Item No. Report of the Interim Director of Planning, Regeneration & Public Realm

Address 14 WESTCOTE RISE RUISLIP

Development: Erection of a rear extension at first floor level and enlargement to porch with fenestration amendments.

LBH Ref Nos: 42360/APP/2022/2419

## PROPOSED ELEVATIONS

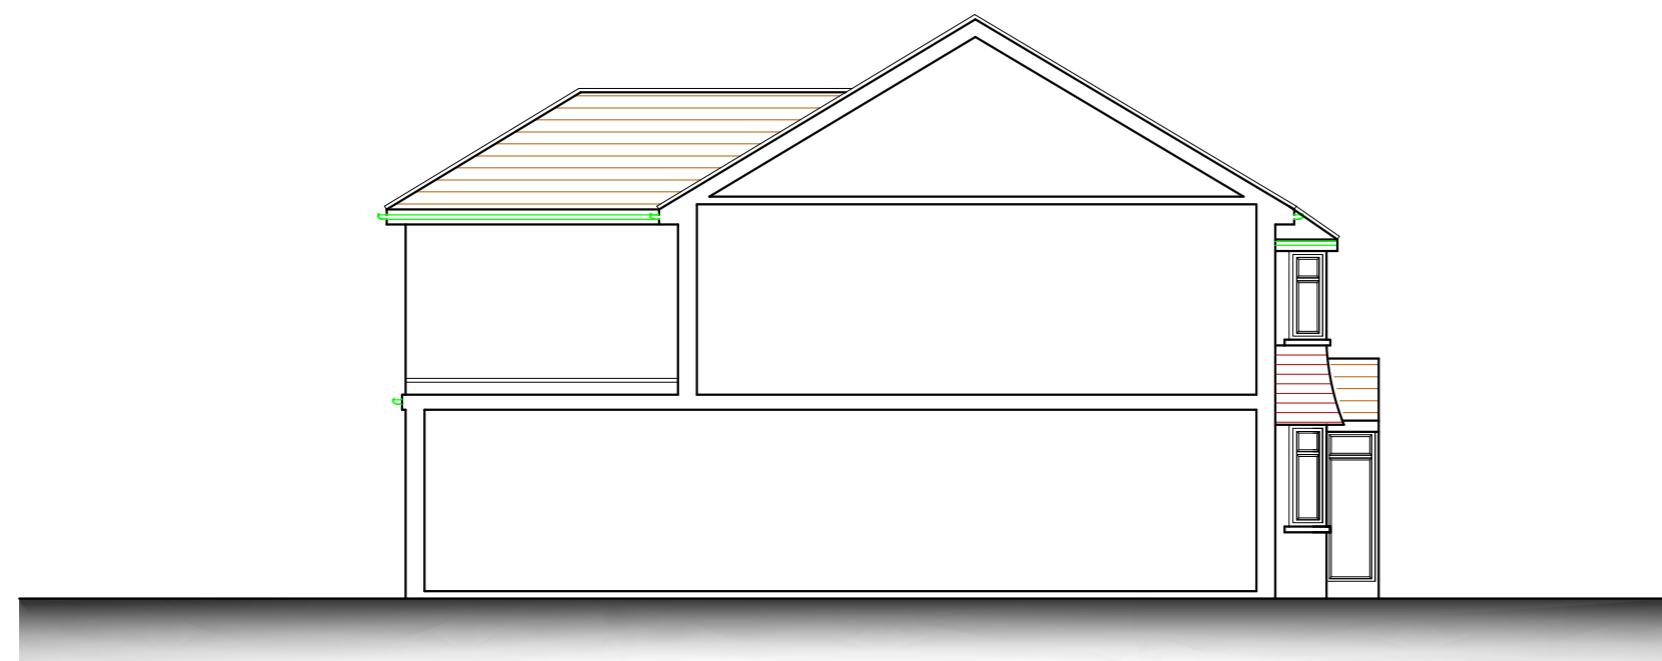
The proposal would extend the existing first floor rear extension, which currently measures 3.6m deep and 2.24m wide. The proposal measures 3.6m deep and 4.57m wide. The extension does not extend into an area provided by a 45-degree line of sight drawn from the centre of the nearest ground or first floor habitable room window of an adjacent properties and does not contain windows or other openings that overlook other houses at a distance of less than 21 metres. The pitched roof on the extension would be of a similar pitch and materials to that of the original roof and reads as subordinate to it in terms of character and design.

The plans also propose fenestration changes, including an additional side window at first floor level. A condition will be added to secure this as permanently obscured glass to at least scale 4 on the Pilkington scale and be non-opening below a height of 1.8 metres taken from internal finished floor level

The proposed window facing 12 Westcote Rise shall be glazed with permanently obscured glass to at least scale 4 on the Pilkington scale and be non-opening below a height of 1.8 metres taken from internal finished floor level for so long as the development remains in existence.

PROPOSED
FLOOR PLANS

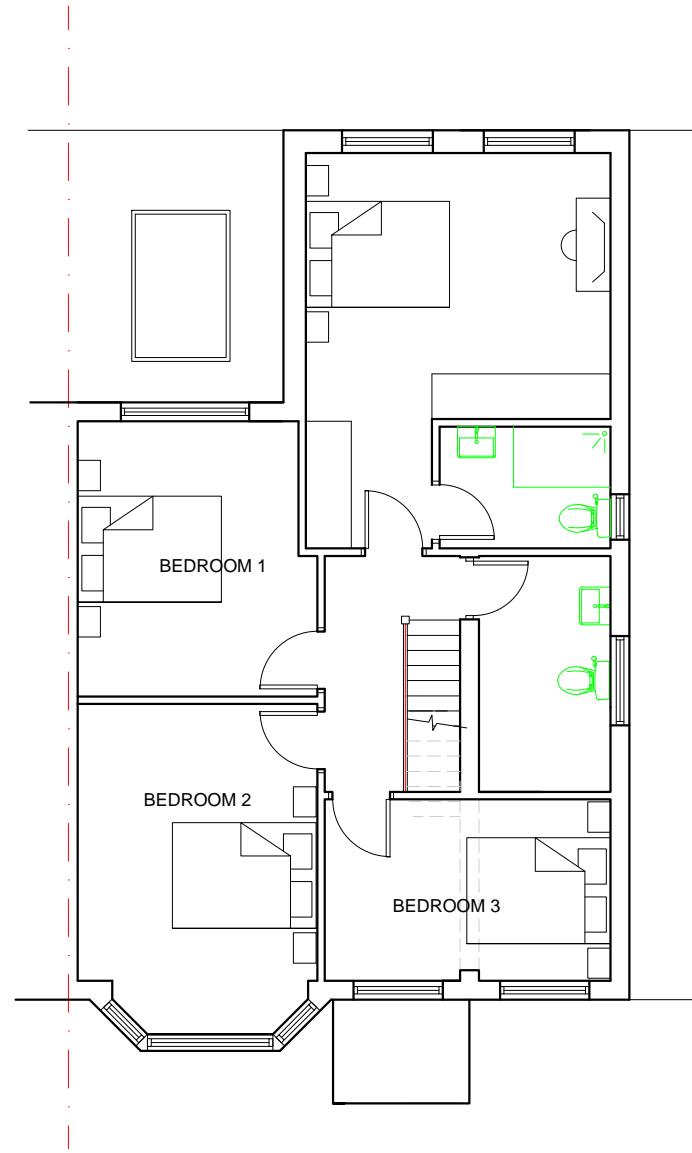
The front porch measures 1.37m in depth and 1.8m in width, on balance it is considered this is acceptable.

The plans proposed the ground floor rear windows and door to be replaced with bi-fold doors. Given that there are no neighbouring to the rear it is acceptable.
